KIRKLEES METROPOLITAN COUNCIL INVESTMENT & REGENERATION SERVICE

DELEGATED DECISION TO DETERMINE APPLICATIONS FOR CONSENT, AGREEMENT OR APPROVAL REQUIRED BY CONDITION

Reference No:	2024/44/92790/W
Site Address:	Victoria Tower, Lumb Lane, Castle Hill, Almondbury, Huddersfield, HD4 6TA
Description:	Discharge of details reserved by conditions 9 (car park), 10 (cycle parking), 11 (electric charge points), 12 (waste), 16 (interpretation boards), 19 (crime prevention), 22 (materials), 25 (boundary treatment), 26 (external lighting) and 28 (landscaping) of previous permission 2018/93591 for erection of restaurant/café/bar, six guest rooms, exhibition/interpretation room, WCs, terrace, car parking and ancillary accommodation
Recommending Officer:	William Simcock

2024/92790

Job Title Castle Hill Visitor Centre, Huddersfield	
Client The Thandi Partnership	
Status Planning	Company AD
Drawing Crime Prevention	Scale @ A1 1:200, 1:500
Date December 2022	Drawn JS
Checked	
Drawing No. 3267 (SK) 111	Revision A

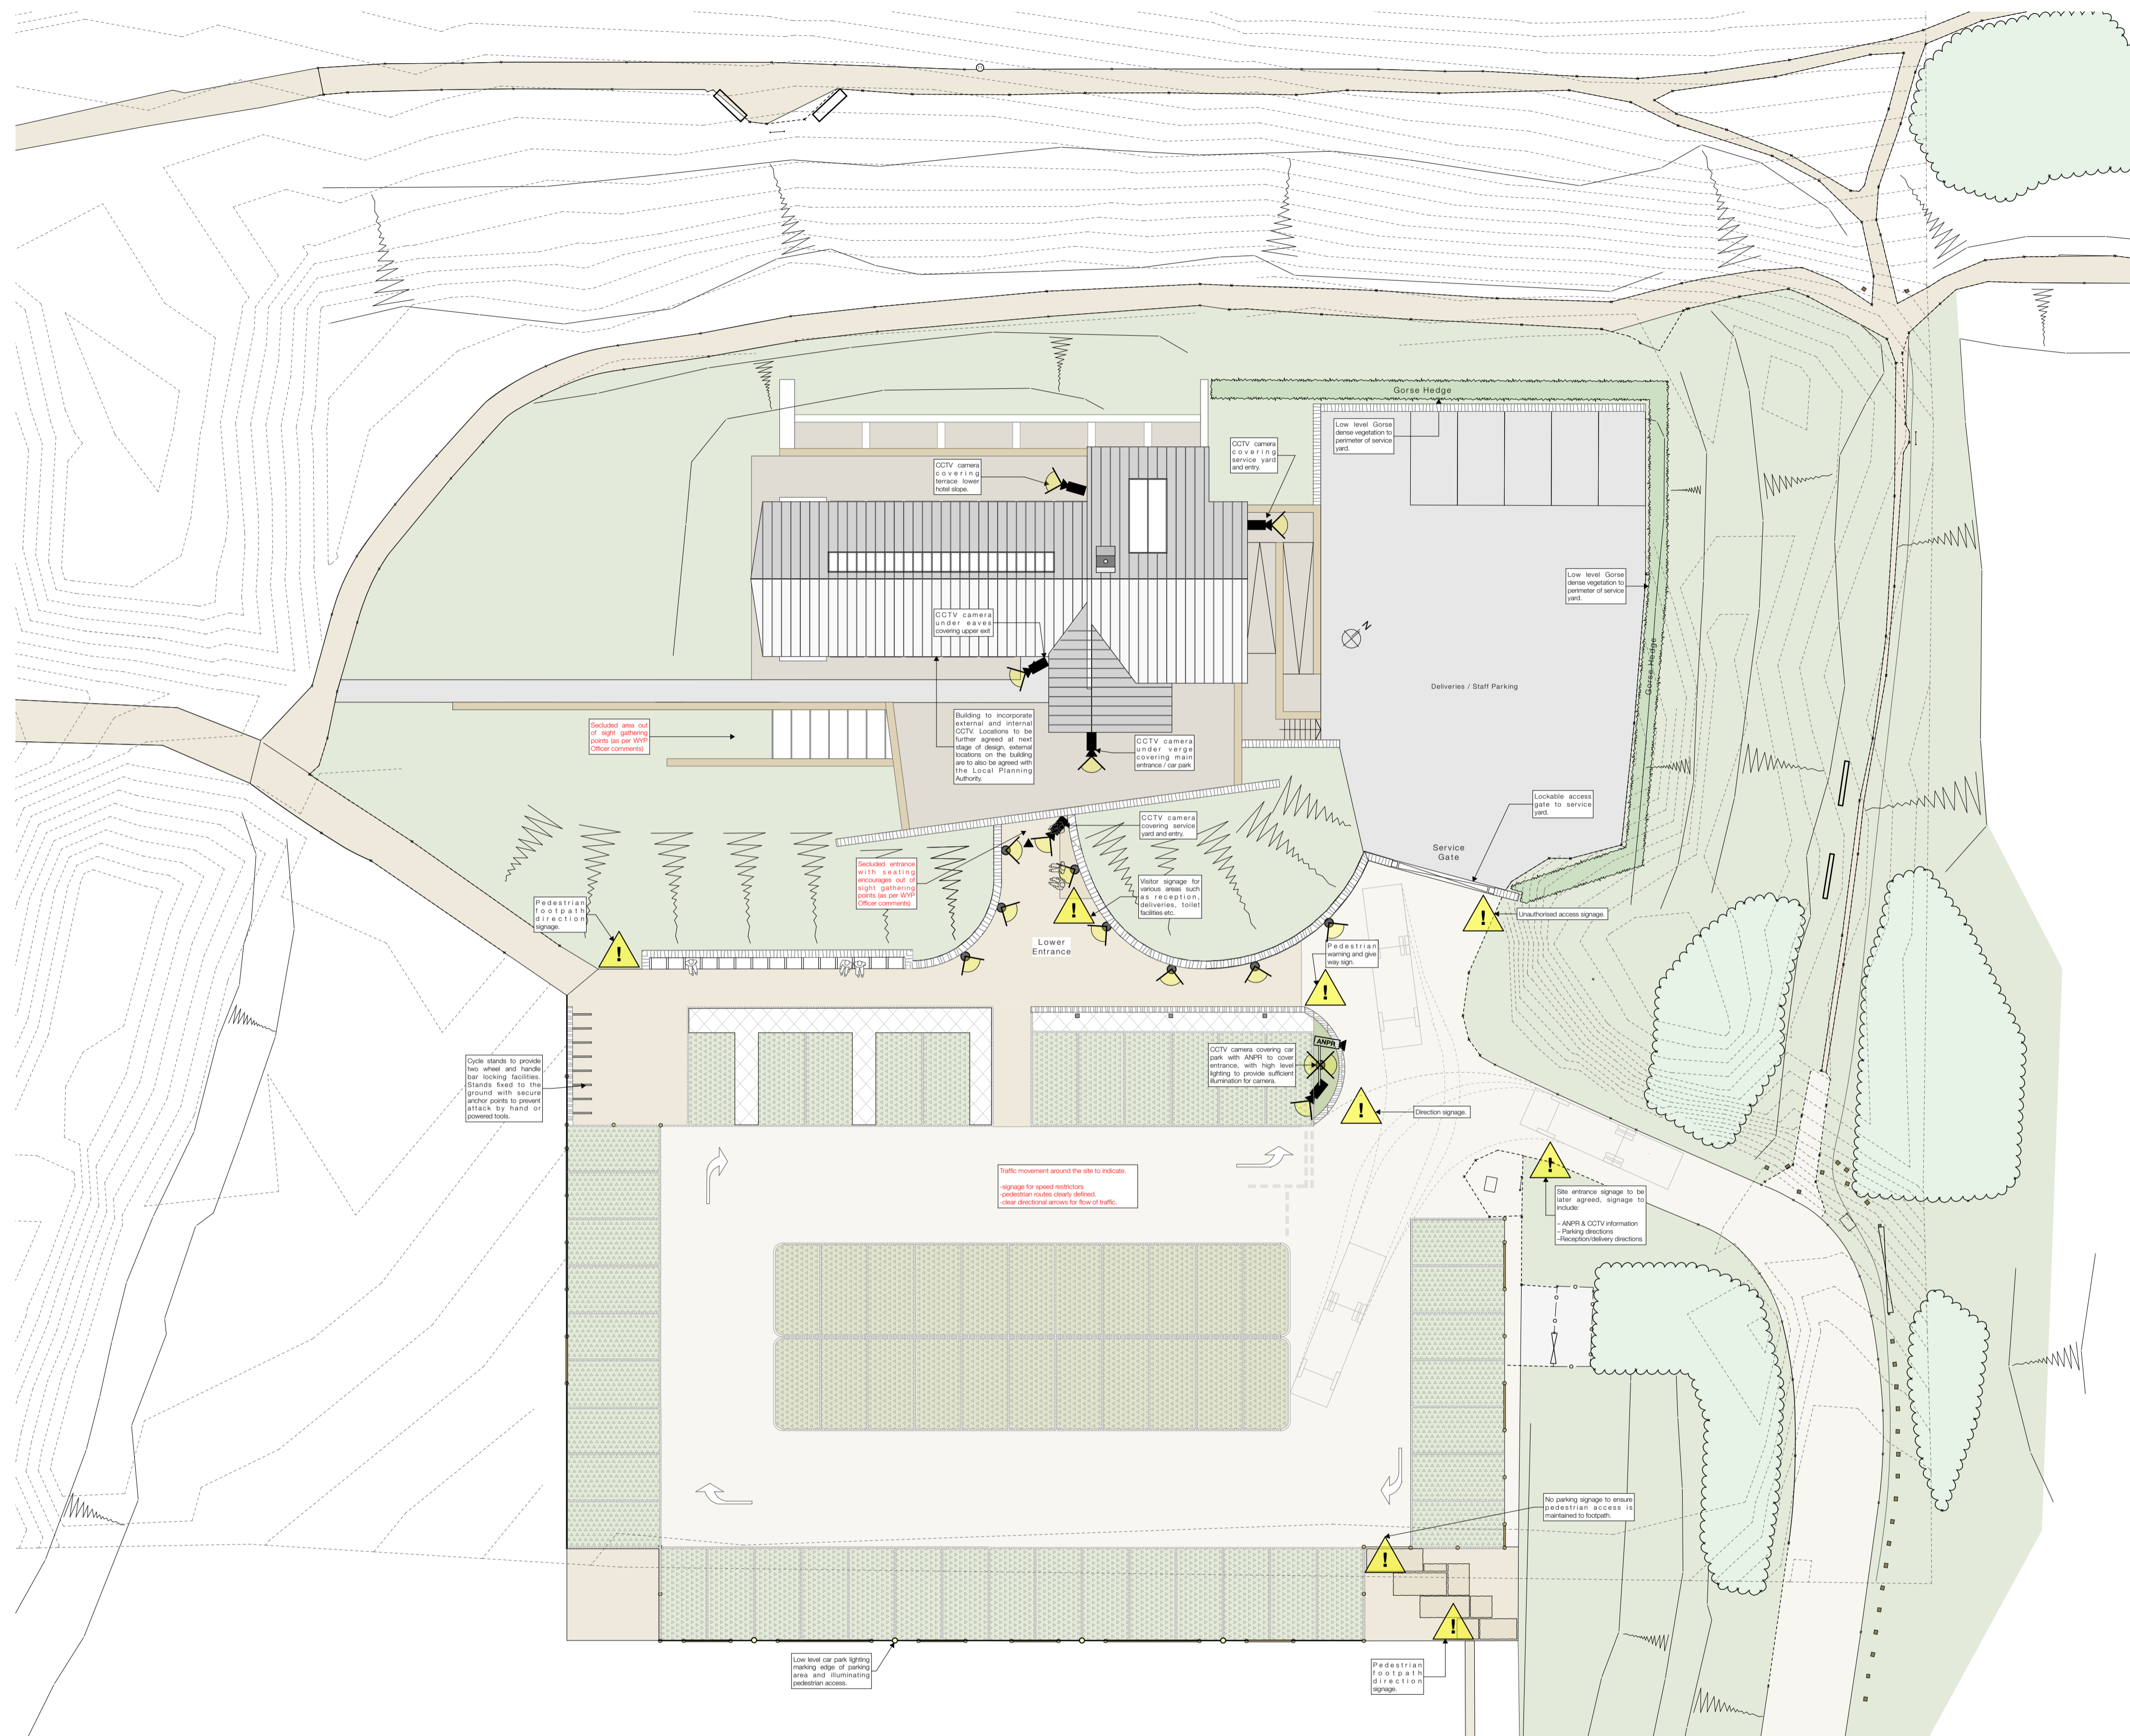
A drawing has been submitted, reference 3287 (SK) 111 Rev A. The following annotation explain the anti-crime measures in detail:

The West Yorkshire Police Designing Out Crime Officer has confirmed that the details in respect of the CCTV camera, ANPR camera, site signage and external landscaping are acceptable.

They have, however, noted that there are no details of access control measures (e.g. lock specifications) although it is noted that it is intended there will be a 24-hour staff presence.

They have also raised concerns about the use of bollard lighting. Alternatives to bollard lighting should be considered (having regard to all other relevant considerations), and it should also be confirmed that the Soprano Wall light and Bega Wall light are fitted above 1.8m so that the spill of light would not be too low. Finally, it has been noted that the car park would have lighting that conforms to BS5489-2013 standard, but that the plans do not indicate the location of the lighting columns. The comments of KC Conservation and Design regarding the illumination of the car park are required.

Until these matters are addressed, the condition cannot be discharged.

Drawing No.: 3287 (SK) 106

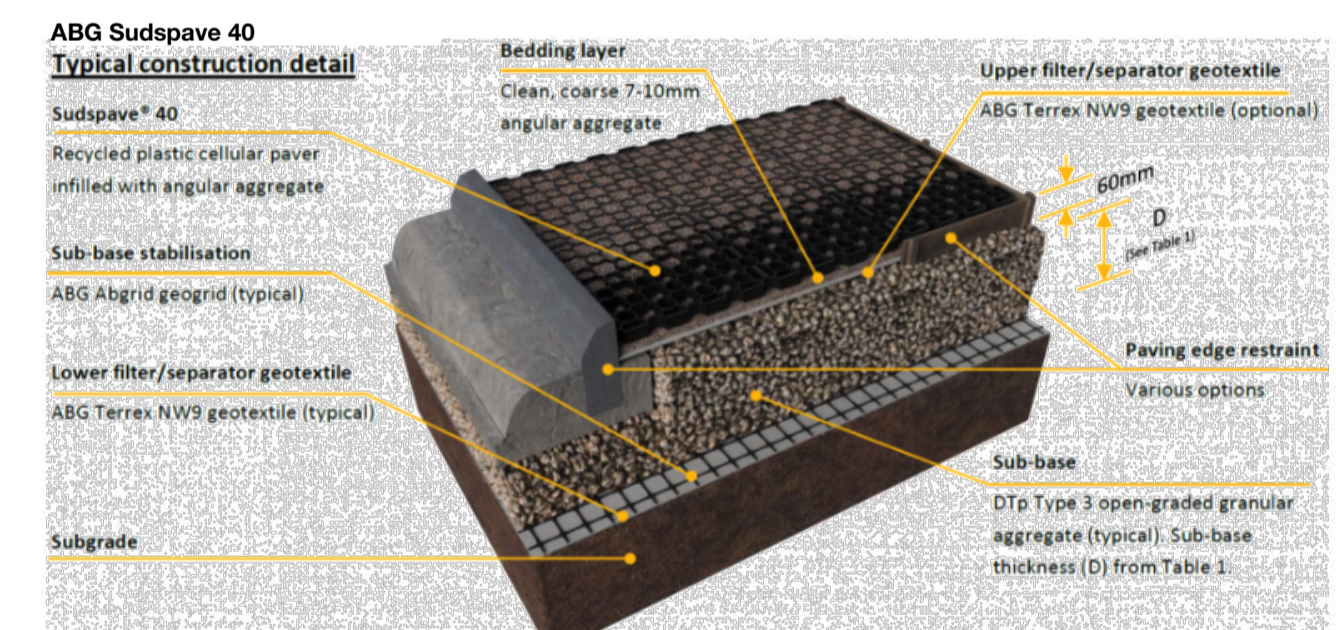
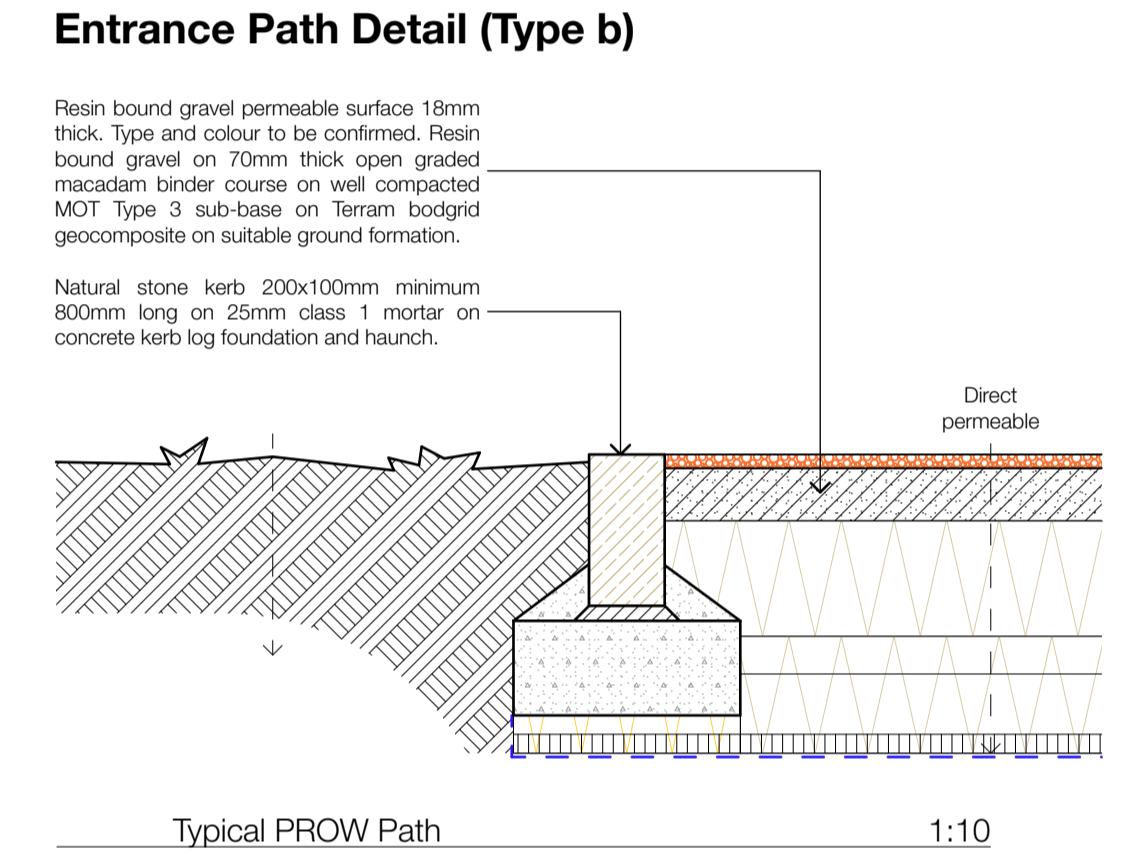
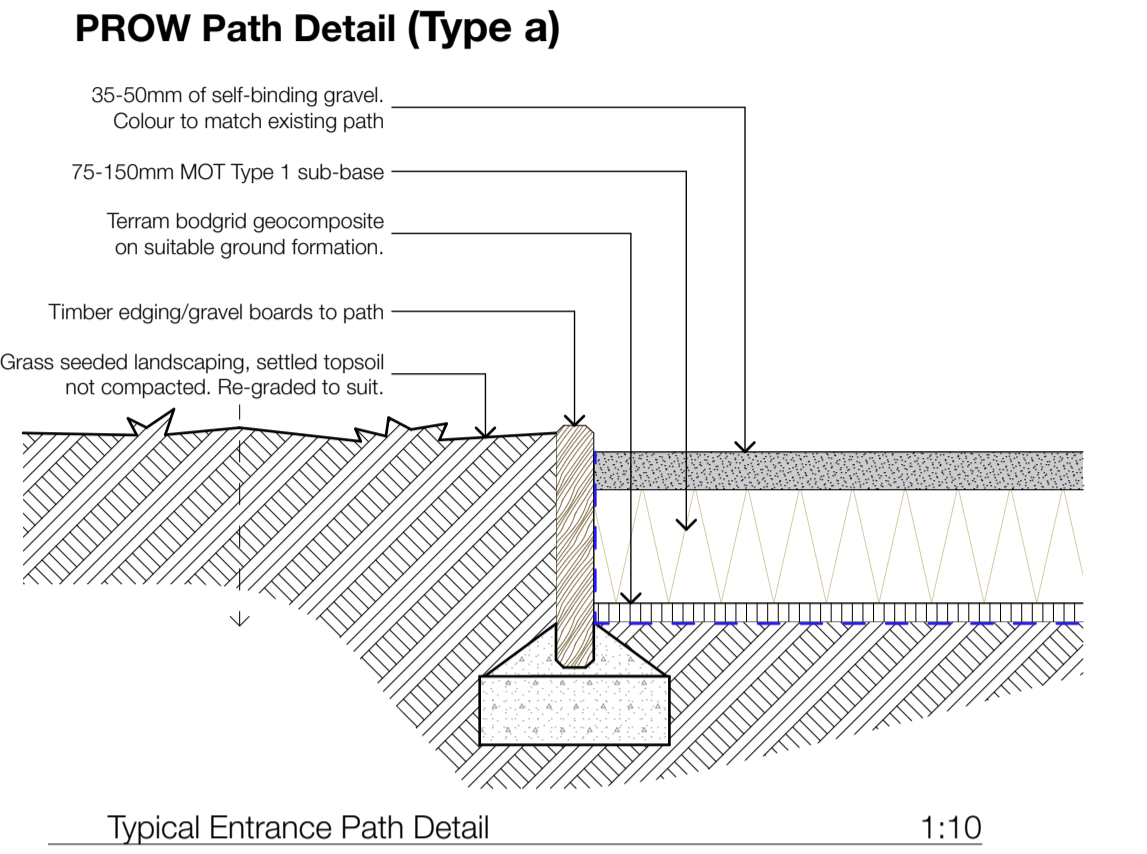
A plan, reference 3287 (SK) 106 rev A showing typical construction detail including surfacing, edging and drainage has been submitted. The surfacing would be permeable.

The views of KC Highways Development Management have been sought and their response is awaited. This condition cannot be discharged at the present time.

Site Castle Hill, Huddersfield, HD4 6TA	Client Castle Hill Hotel Heritage Limited
Plan Planting and Faunal Box Plan	Author AWe
Plan ref 01	Revision 00

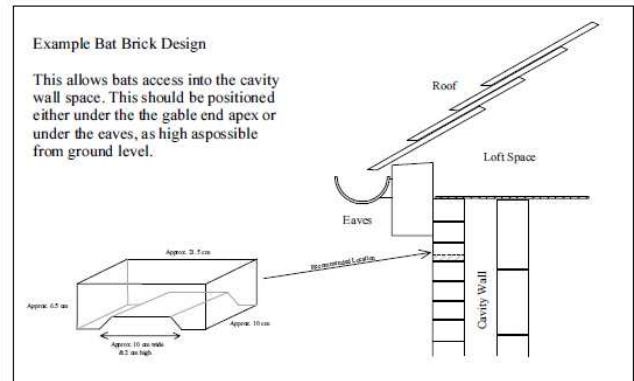
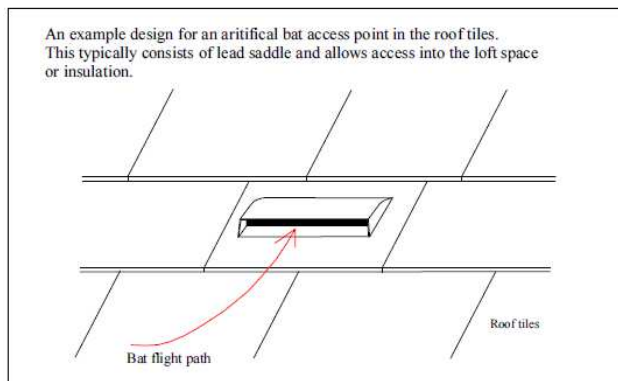
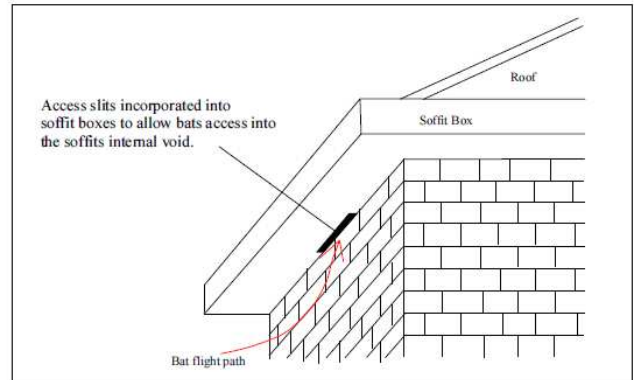
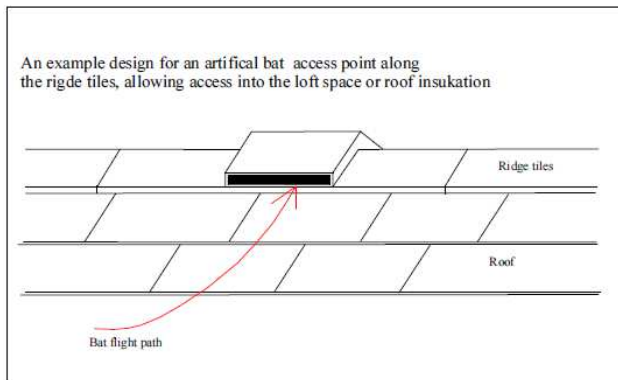
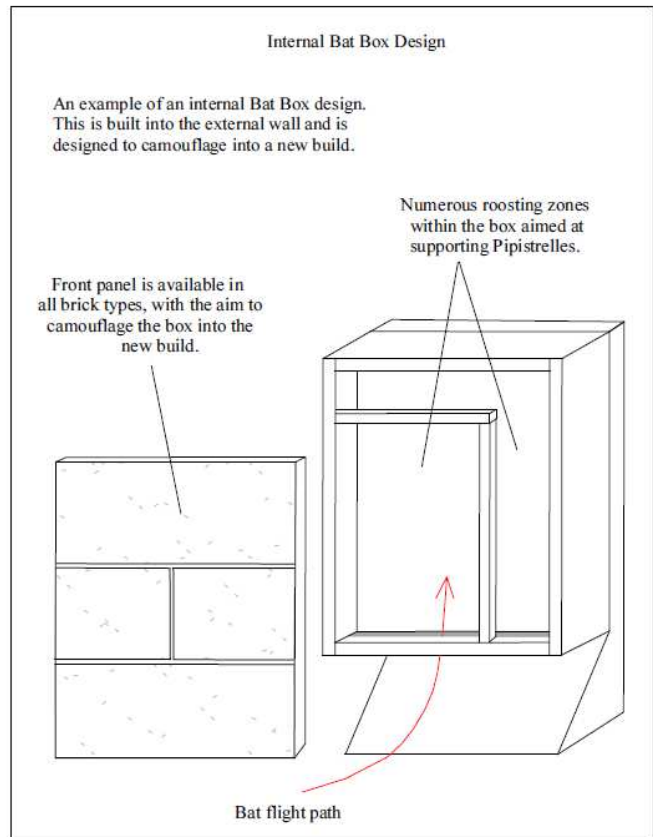
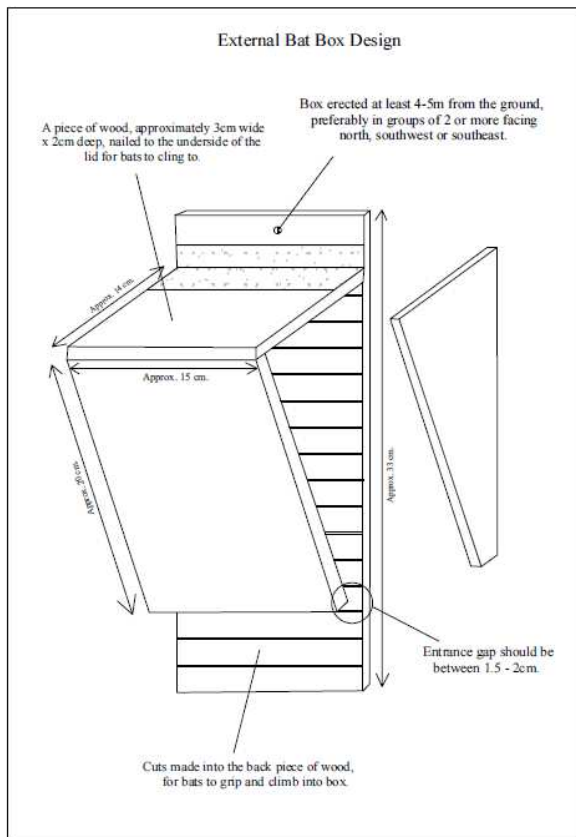
A landscape and ecological management plan (LEMP), reference 21112a/Awe, has been submitted.

Details of existing and proposed levels, of initial aftercare and long-term maintenance, monitoring and remedial measures, are not included within the LEMP.

This condition therefore cannot be discharged at the present time.
